DRAWING NO: SZC-SZ0100-XX-000-DRW-100205	REVISION: 02
DATE: JULY 2021	DRAWN: CGK
	SCALE: AS SHOWN @ A1

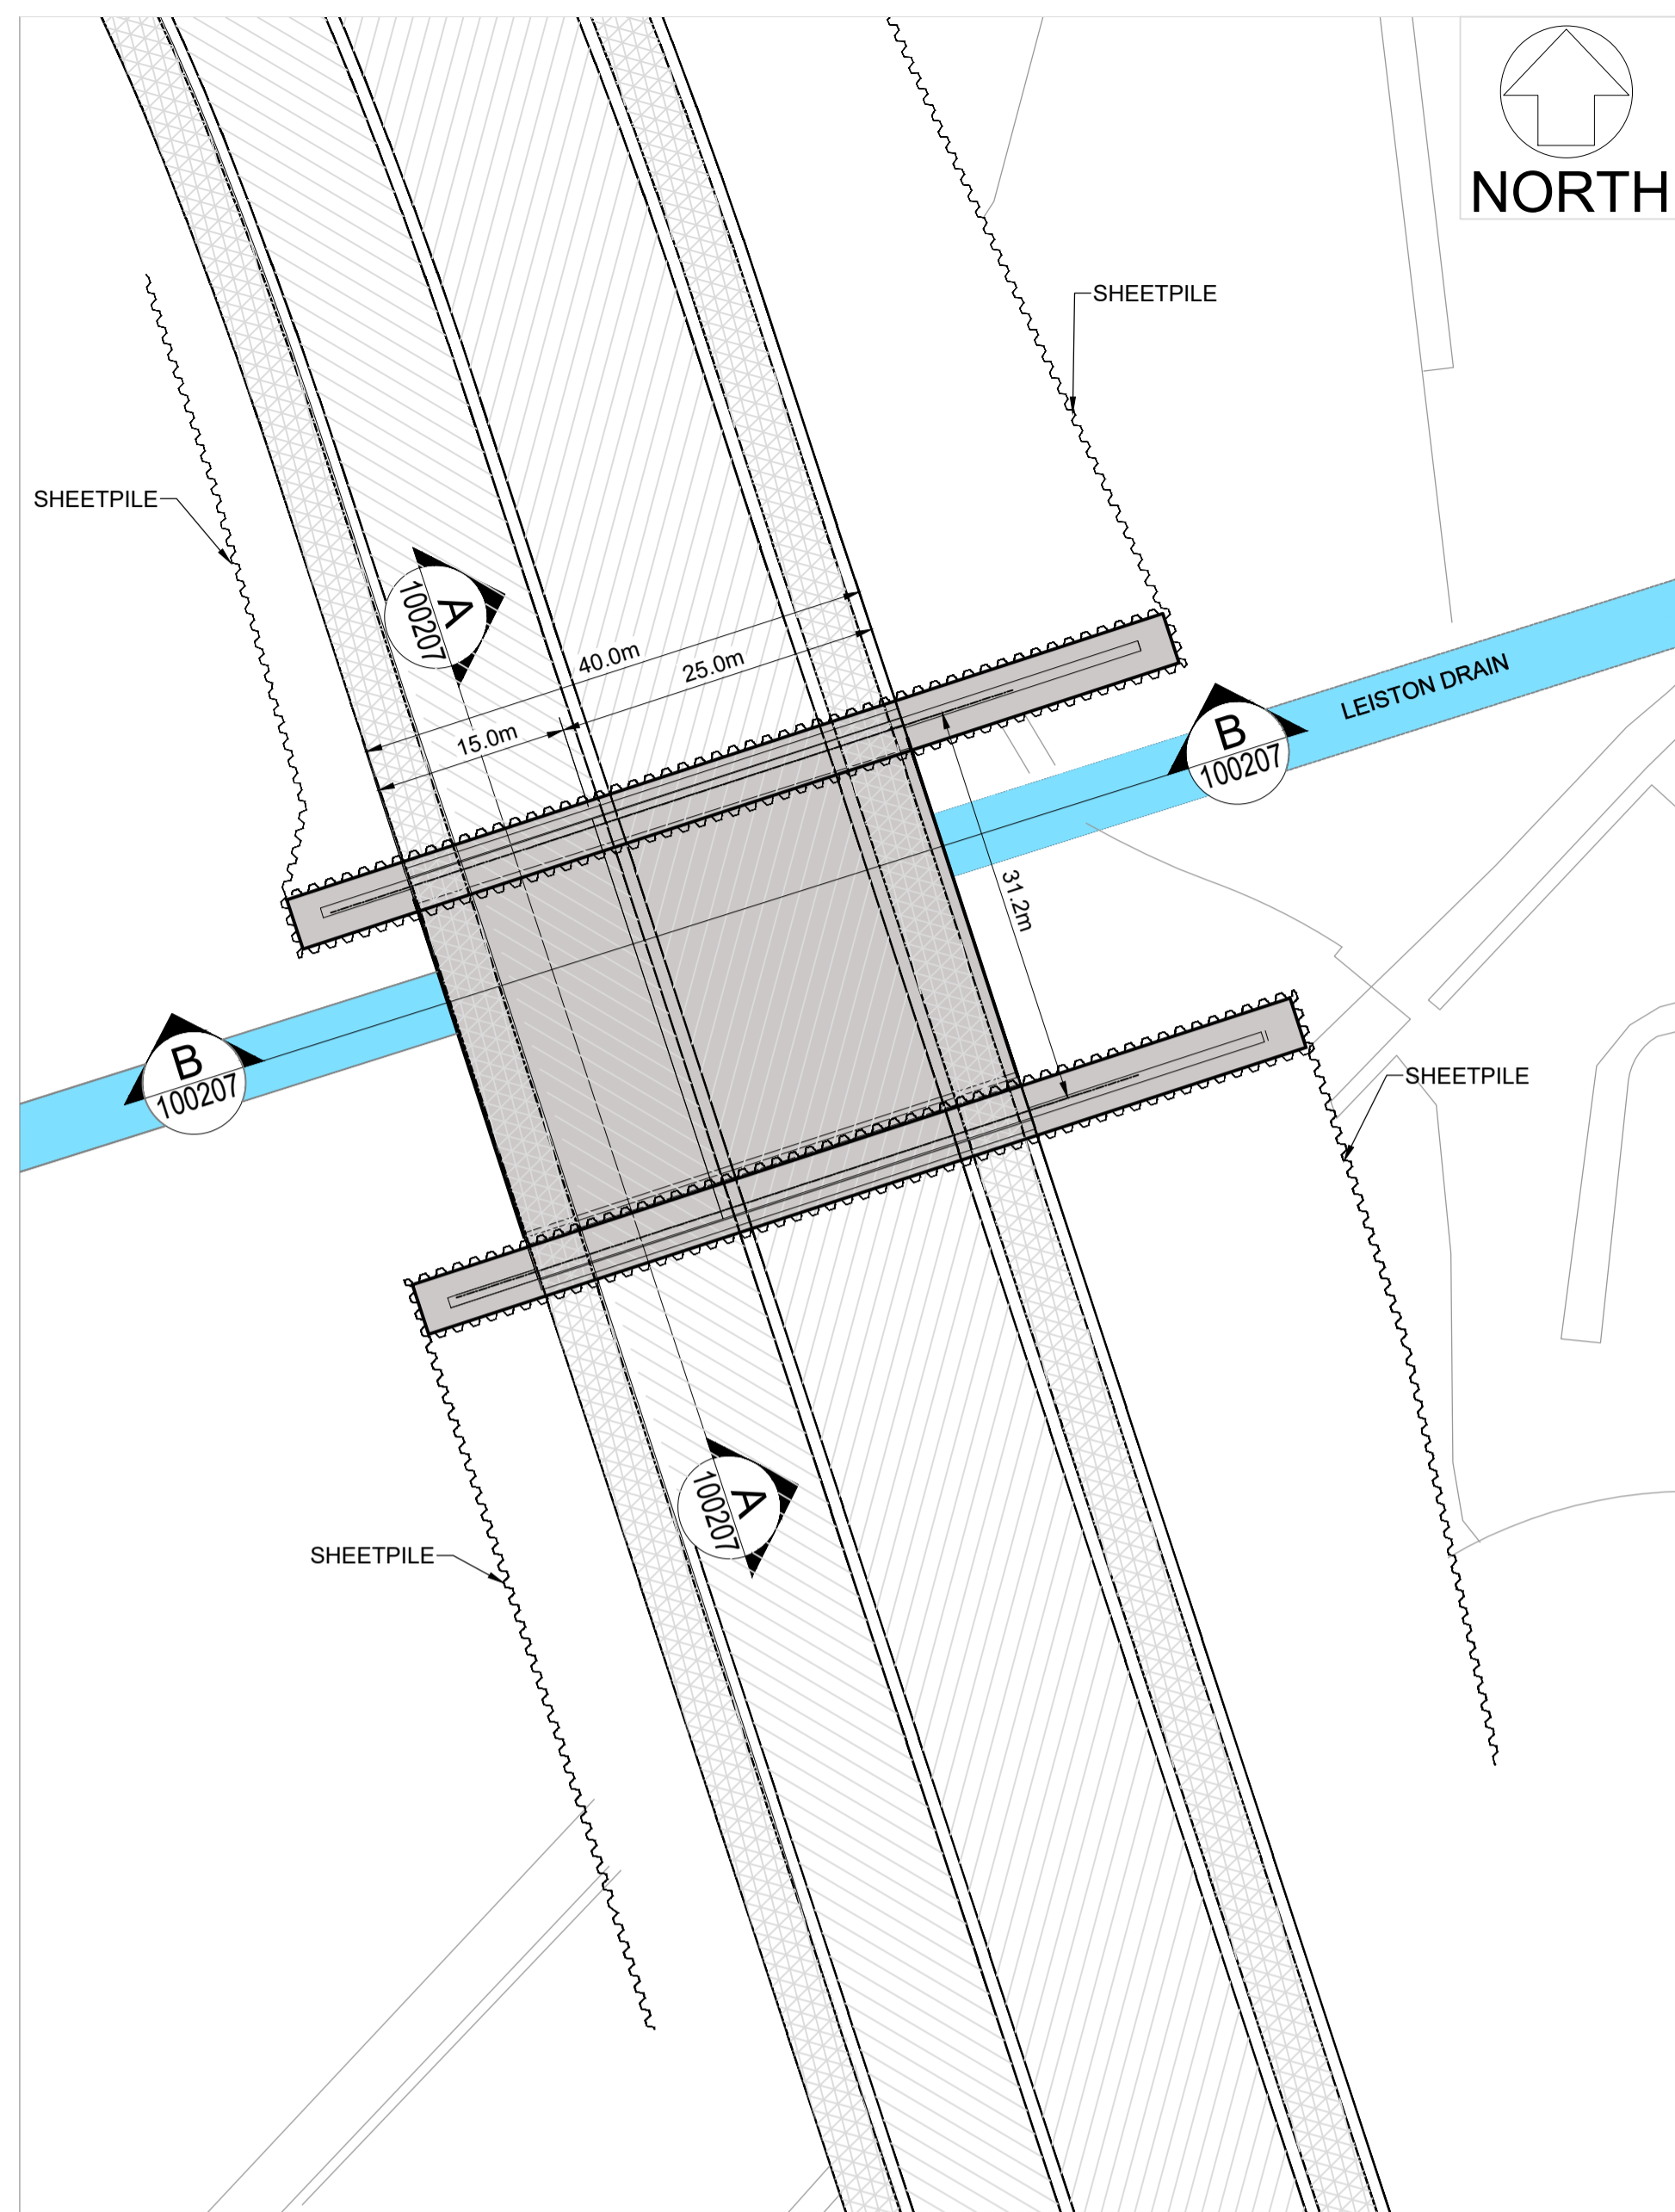
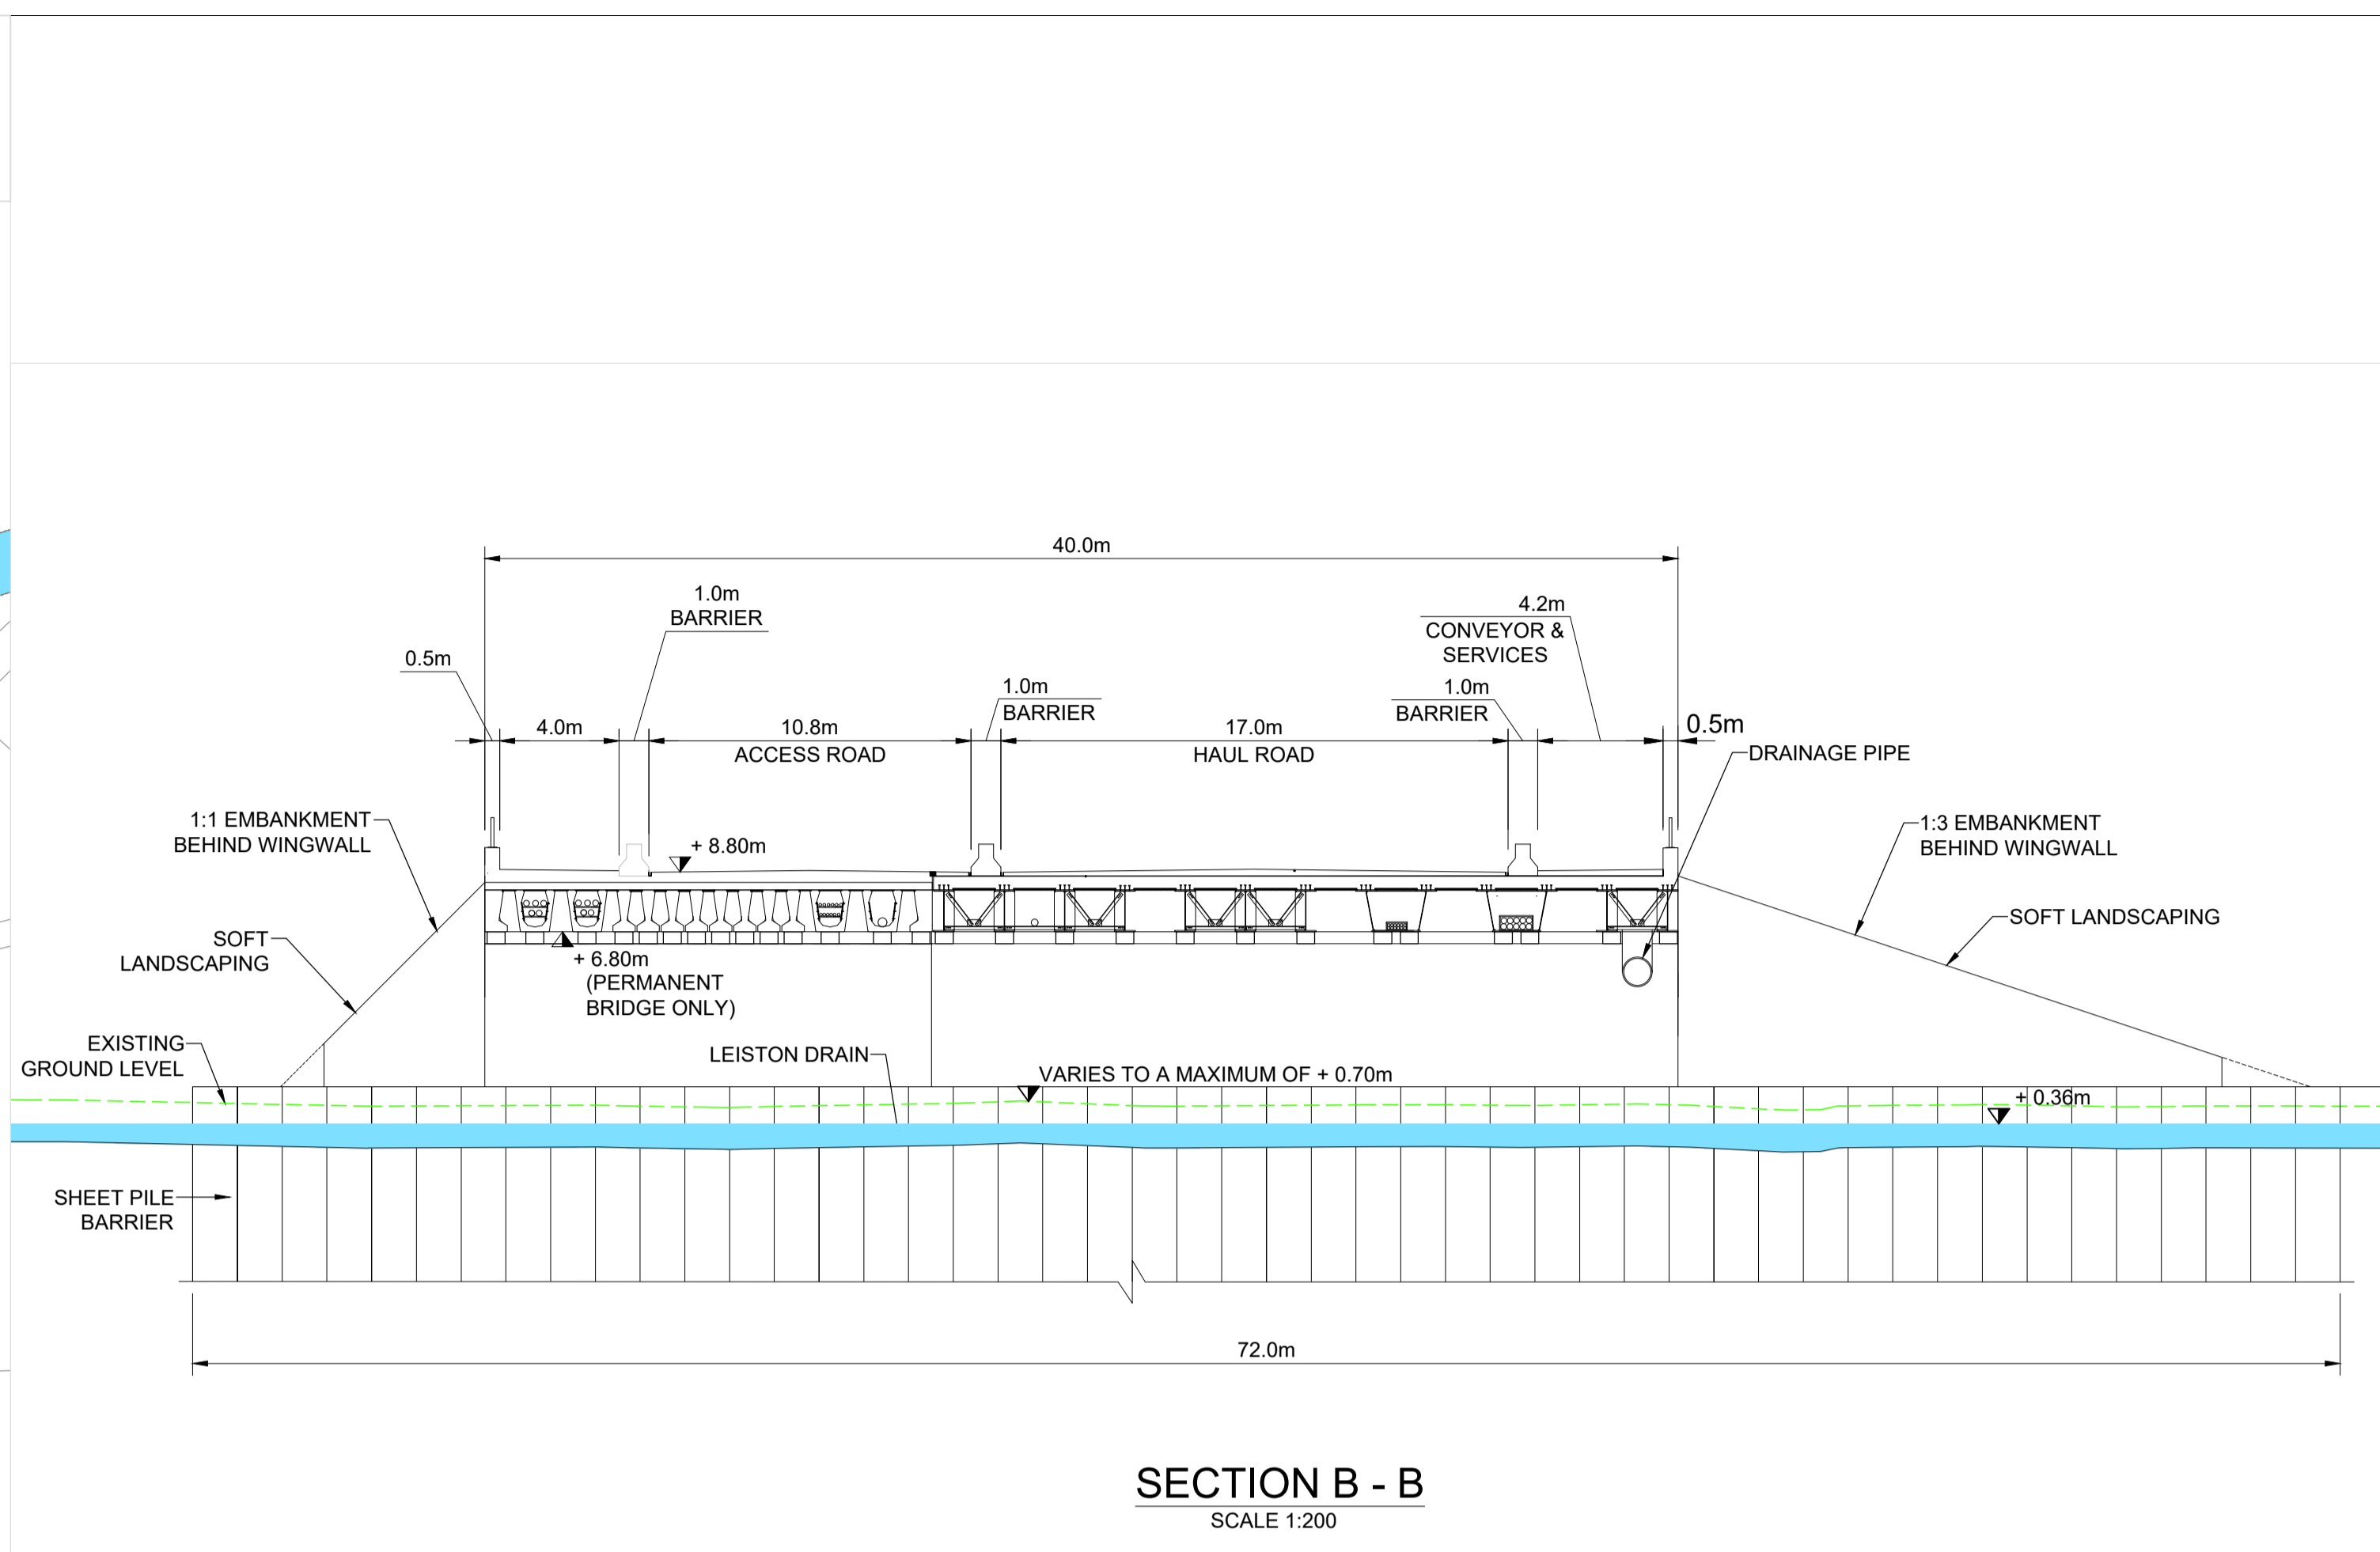
“It is assumed that connecting pipework between the proposed location of the desalination plant within the temporary construction area and the marine infrastructure would run across the SSSI crossing above the soffit level of the bridge.”

Q13 Given the importance of the SSSI, can the Applicant explain why; firstly they only advise “It is assumed connecting pipework between...would run across the SSSI crossing...” and secondly; what safeguards are there within the pipework design and the proposed SSSI crossing to specifically safeguard against seepage from the pipework be it; accidentally, through poor maintenance, vehicle collision, etc.
